Submission for Job: #6010 SSD 6010 - One Residential Building (Student Accommodation) within Darling Drive Plot

Site: #2824 SICEEP Site, The Haymarket; Darling Drive, Sydney

30 July 2013

Summary

SHADOW DIAGRAMS: PERSPECTIVE, SHOWING THE PEAK, WINTER SOLSTICE

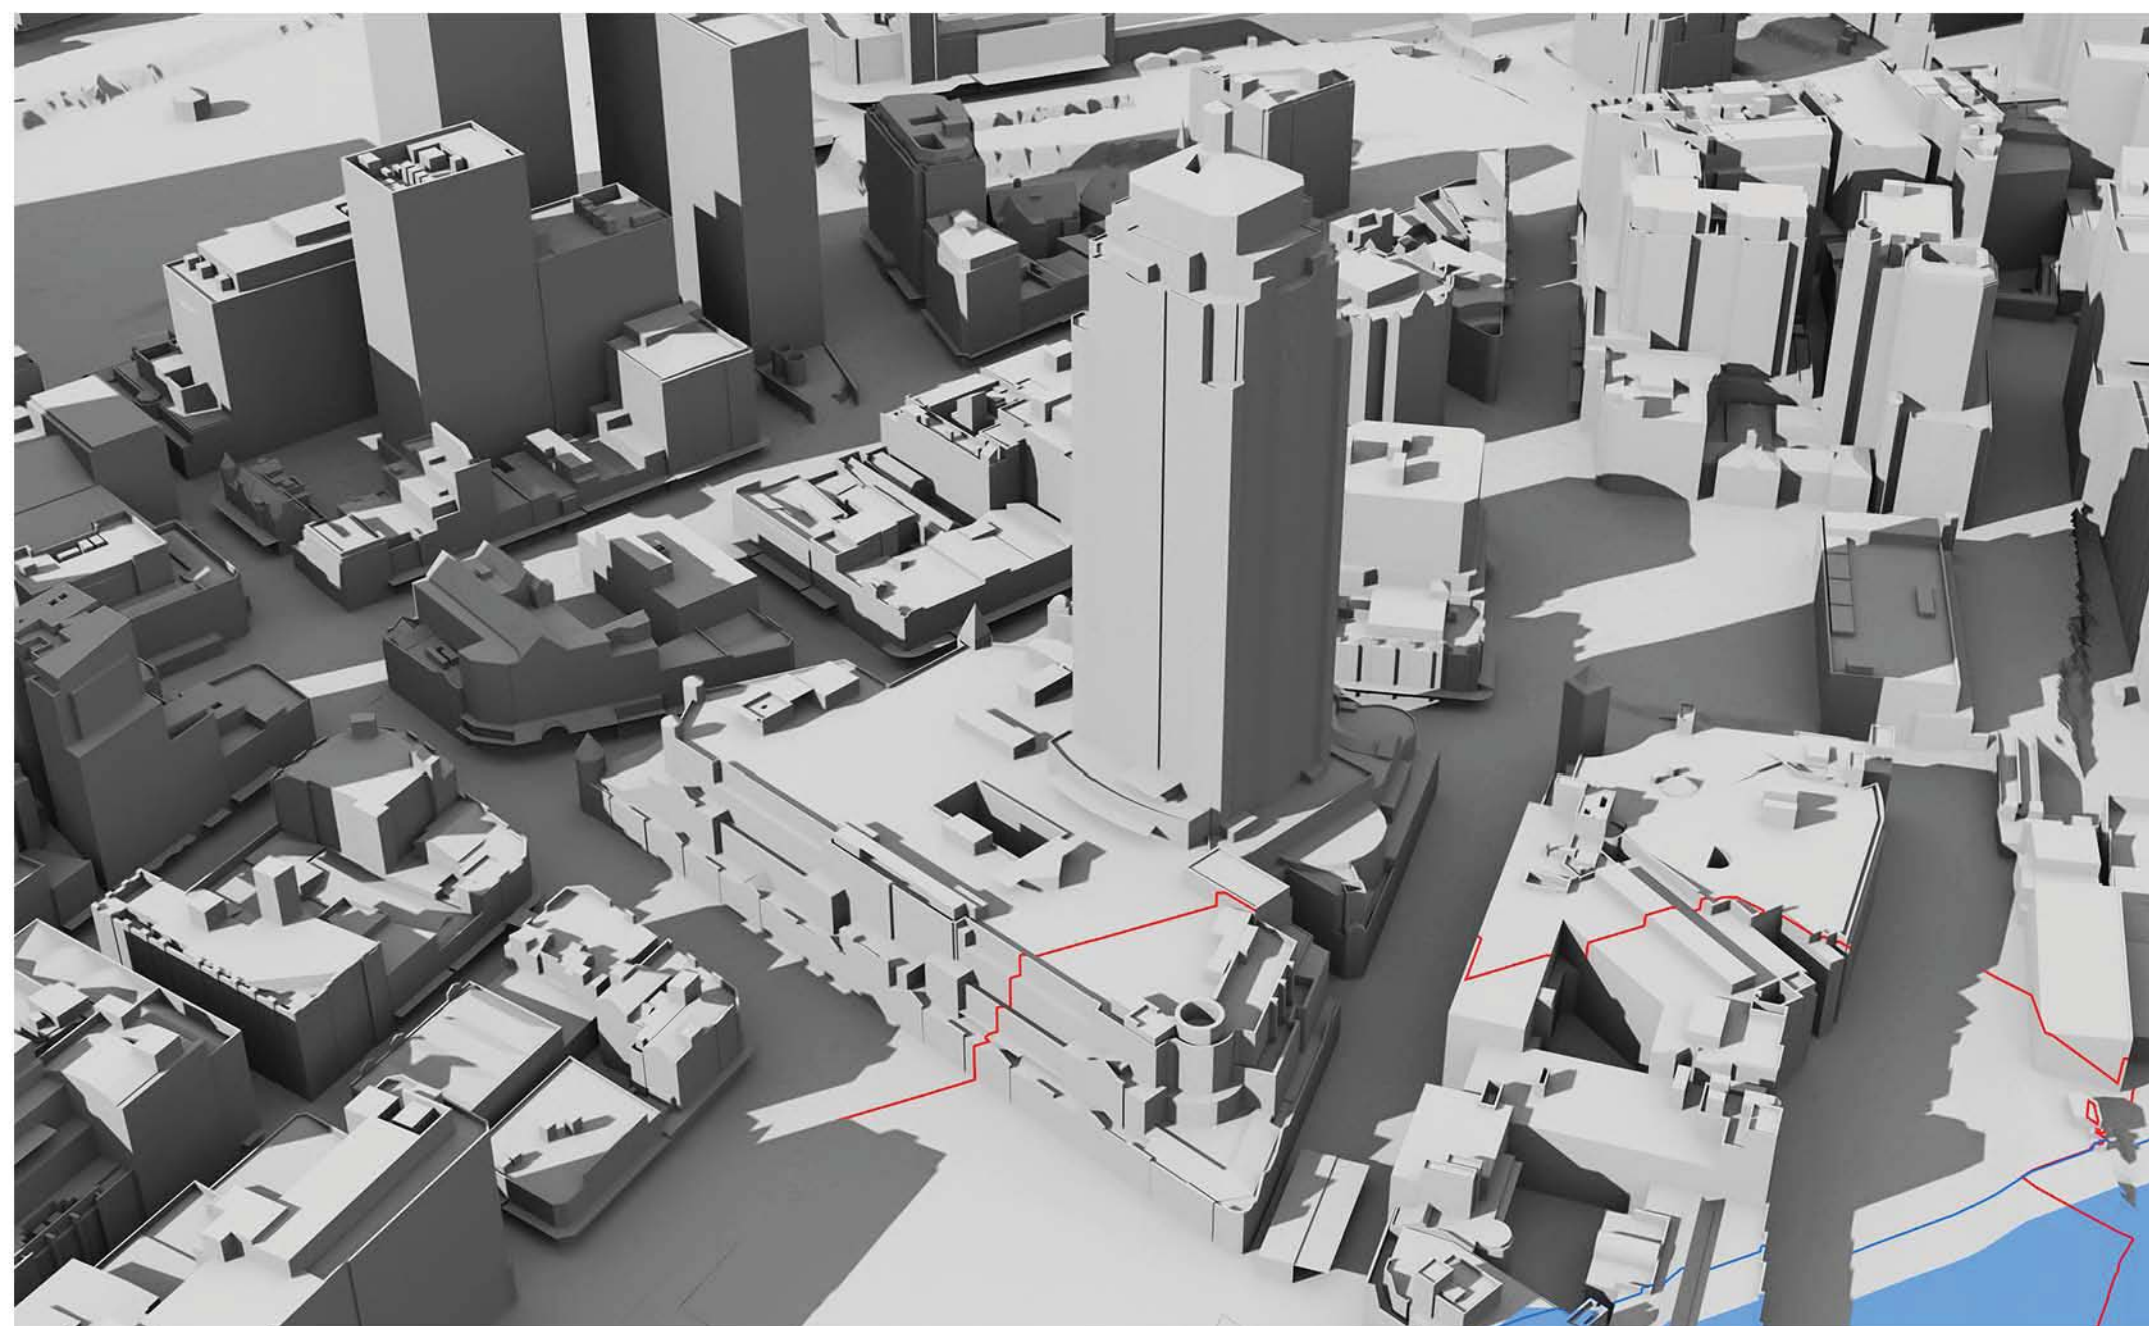
The proponent provides diagrams but fails to discuss the existing shadowing of the west façade of The Peak.

We refer to the shadow diagrams in SSD5878, Appendix H. Supplementary Design Report, Section 6. Amendments, Winter solstice - 22 June. This is not 21 June, but there would be no noticeable difference.

At 9am, 10am and 11am the west façade is totally in shadow due to other parts of The Peak building itself.

At 12pm there is still substantial existing shadowing on the west façade caused by the irregular shape of the west facade.

At 1pm the existing shadowing has been substantially removed, but not totally removed.

It can be concluded that some single aspect apartments on the west façade and some south-west dual aspect corner apartments currently receive less than 2 hours direct sunlight to habitable rooms and 50% of the private open space between 9am and 3pm on 21 June.

At 9am, 10am and 11am the west façade is totally in shadow due to other parts of The Peak building itself.

At 12pm there is still substantial existing shadowing on the west façade caused by the irregular shape of the west facade.

At 1pm the existing shadowing has been substantially, although not entirely, removed. However, overshadowing of lower levels of the west façade by the concept proposal parameter plan shadows for the N,NE and SE plots has already started.

By 2pm the existing shadowing has been totally removed. However, overshadowing of the west façade by the SSDA4 and SSDA5 buildings has appeared and risen further up the west façade than the concept proposal parameter plan shadows for the N,NE and SE plots, which is still present.

At 3pm, the proponent states correctly that 45-45% of the western façade is overshadowed by the SSDA4 and SSDA5 buildings.

It can be concluded that, as a result of combination of the proposed development with existing shadowing of the west façade, some single aspect apartments on the west façade and the south-west dual aspect corner apartments which currently receive less than 2 hours direct sunlight to habitable rooms and 50% of the private open space between 9am and 3pm on 21 June will suffer additional overshadowing. It is beyond our skills to count the number of such apartments. We note that the proponent has made no attempt to do so.

Rather than counting the number of units which will not meet the DCP guidelines, the proponent attempts to trade-off direct sunlight at 4pm for lack of direct sunlight during the period 9am to 3pm. There is no provision in the DCP guidelines for such a trade-off.
